Rezoning Transportation Analysis

Petition Number: 2023-088

From: Jake Carpenter, PE
Jacob.carpenter@charlottenc.gov
980-221-5675

Revision Log:	Date	Description
	07-26-23	First Review (PM)

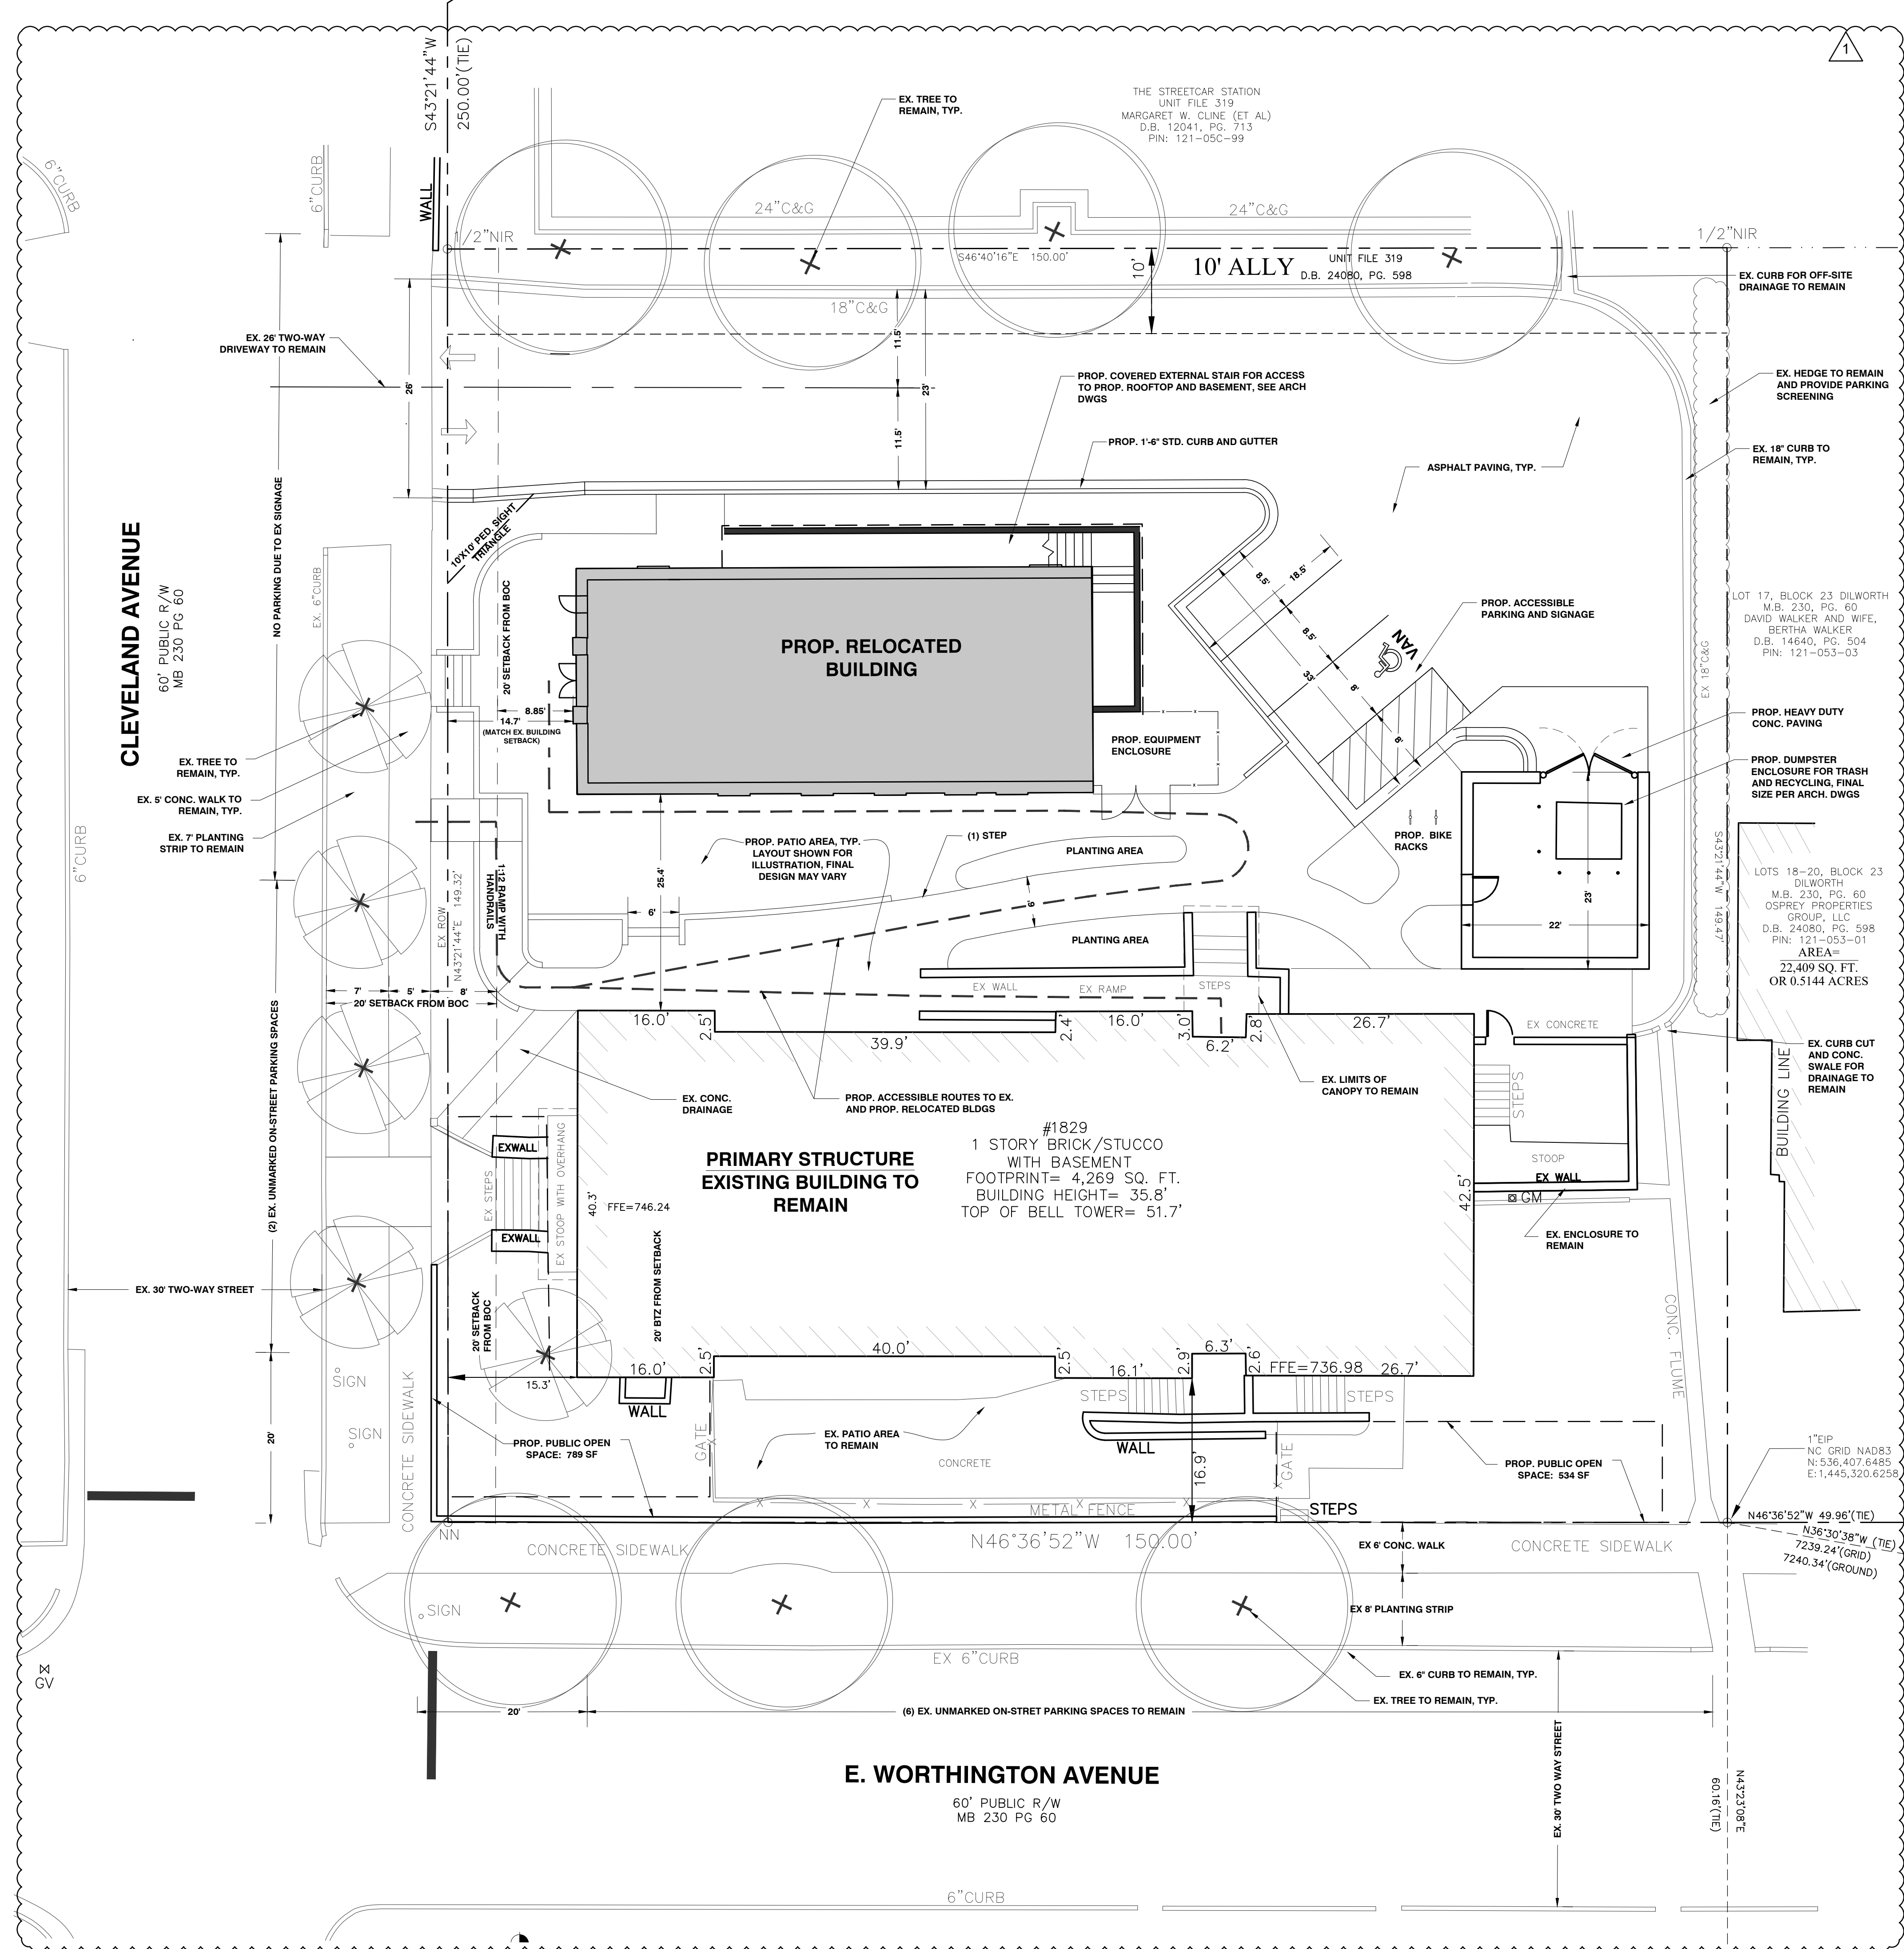
1. Curblines:

- a. **Cleveland Avenue:** The future location of curb and gutter is to be located at 20.5ft per CLDM U-05 series for local commercial wide street typical section.
- b. **Worthington Avenue:** The future location of curb and gutter is to be located at 20.5ft per CLDM U-05 series for local commercial wide street typical section.

NOTE: Additional distance from center line to back of curb may be required in locations where a median is present or around intersections and interchanges.

Label and dimension the future back of curb location from the centerline for each road on the site plan.

4. Revise site plan to show the centerline on each public street. Dimension the right-of-way and the back of curb from the centerline.
5. Revise site plan to clarify if the wall is proposed or existing. If the existing wall is being replaced, CDOT would prefer that it be placed outside of the right-of-way, otherwise will need an encroachment agreement.
